City of Albuquerque Stormwater Construction Site Inspection Report

ESC File No.	M10E020	Project Name:	Kidz Academy and The Human Bean		
NPDES Id. No.	NMR1003NO/NMR1003NP	Location:	7800 Sage Rd. SW		
2/14/2022	Owner	Contractor			
Operator	Kidz Academy and Tres Lobos	Creative Design Builders			
Contact name & title	Keith Griego	Raymond Herrera			
e-mail	kidzacademystaff@gmail.com	rhcdb46@yahoo.com			
Contact Phone #	505-681-7812	505-410-9020			
COA Inspector	Doug Hughes	Start/End Time:	4pm		
Construction Phase:	Vertical				
Type of Inspection:	Regular	Storm Event	Past Storm Event >0.25"	311/Complaint	Follow Up
Weather at time of inspection?		clear		Temperature: ~	40
Estimated date of last storm 0.25" or greater		1/1/2022

TEMPORARY EROSION AND SEDIMENT CONTROL PLAN

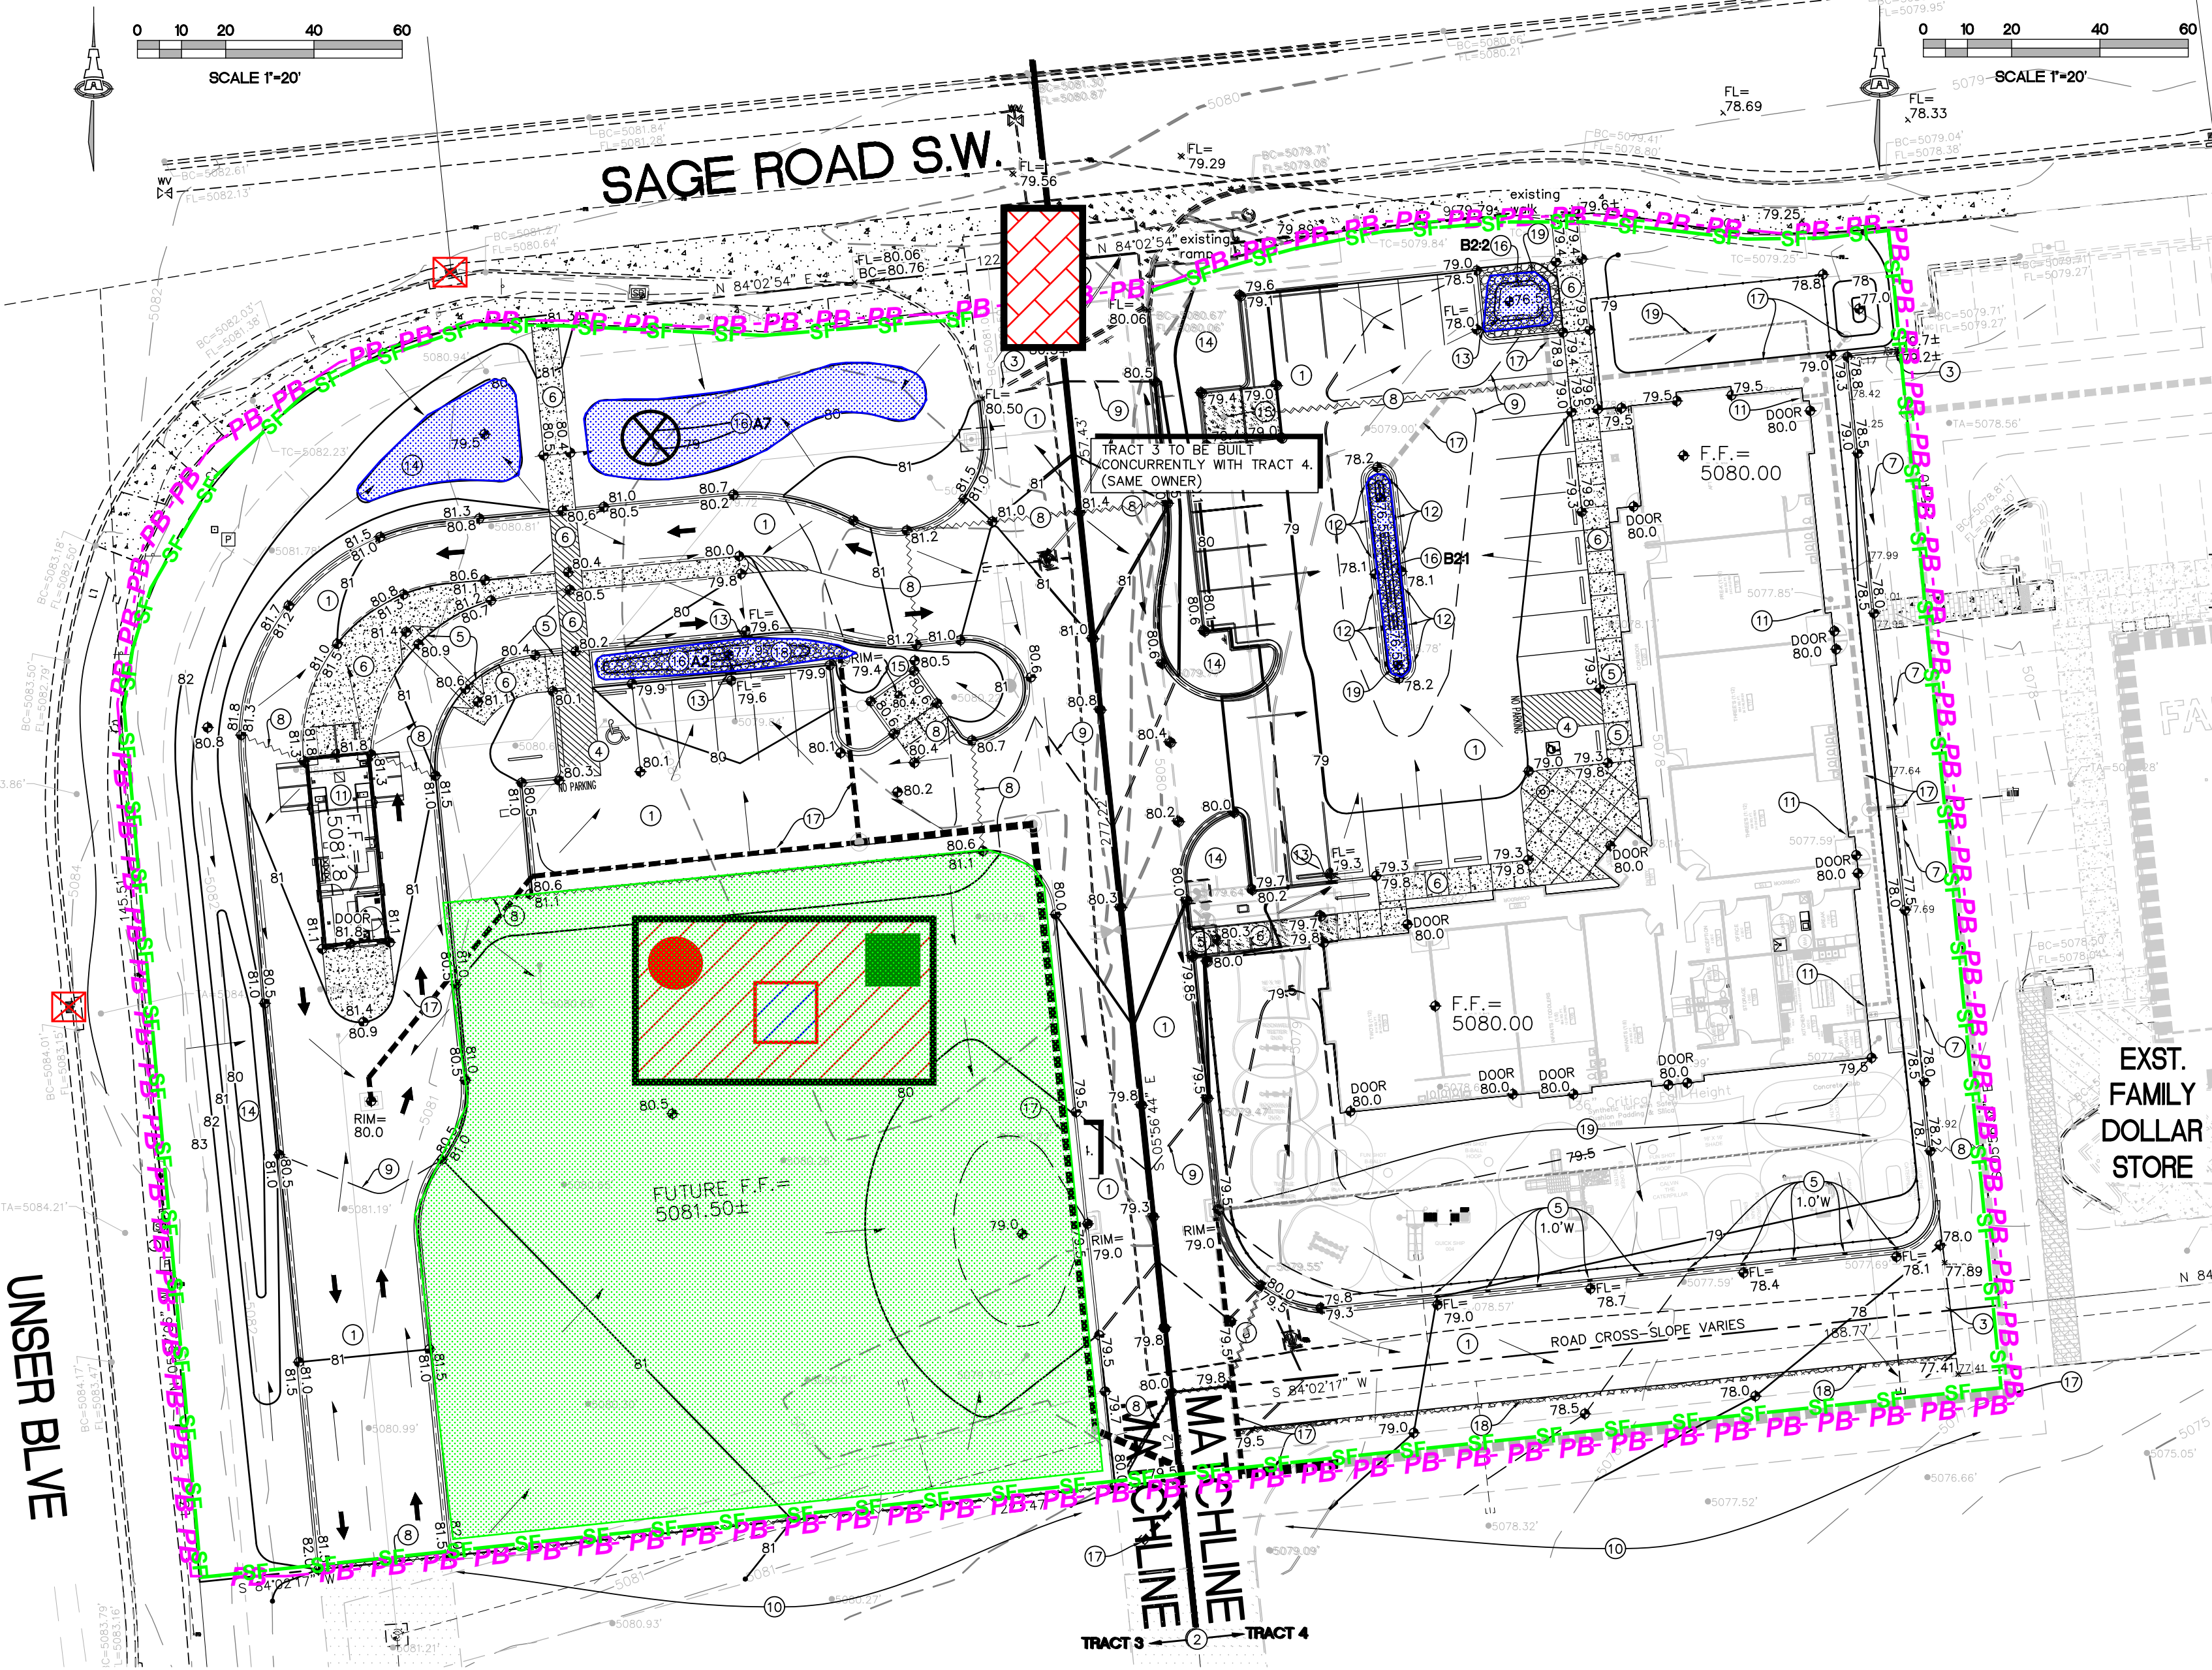
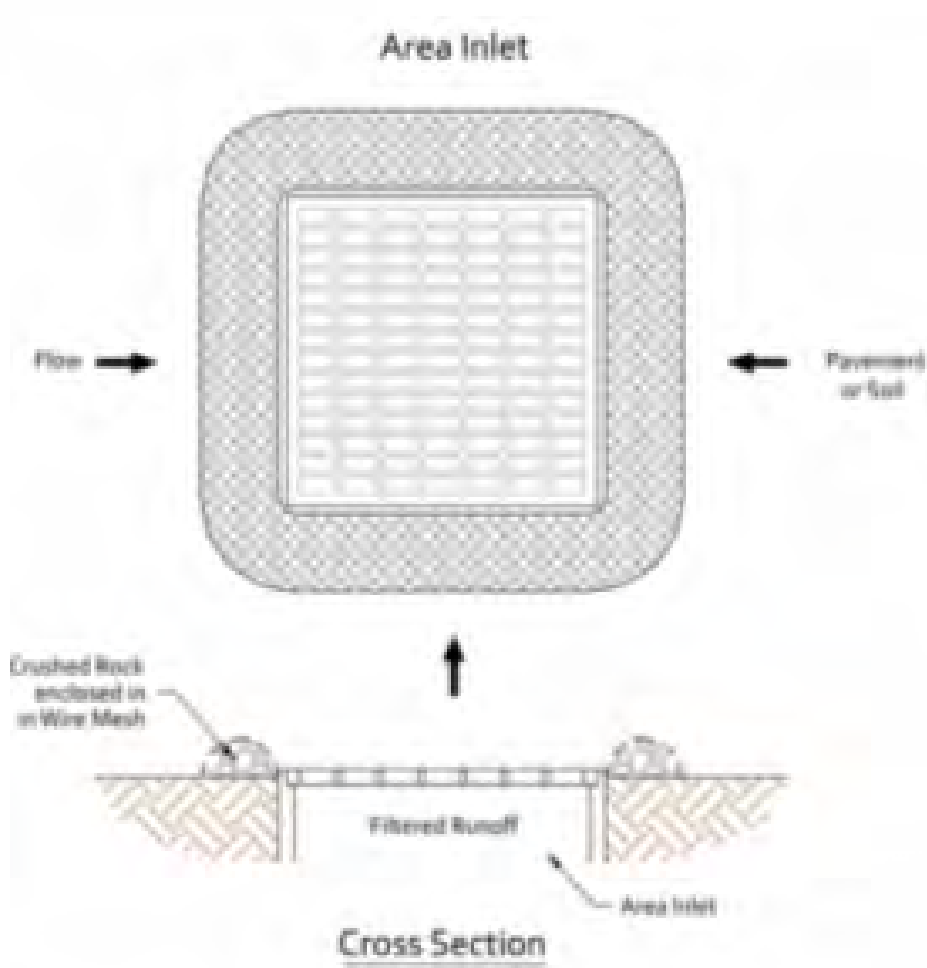
Item Number	Deficiency/ Corrective Action				
1	Inlet Protection in Sage downstream of the site is not maintained and and there is too much sediment in the street upstream of the inlet. Sediment must be removed from Sage and from the parking lot east of Kidz Academy and the inlet protection reset.				
2	Silt fence is missing both onsite and on the south neighbor's property where disturbed.				
3	Cover (SEED AND Mulch) is required in all areas to remain inactive for 14 days or more including dirt between buildings onsite, street frontage, and new disturbance south of south driveway.				
4
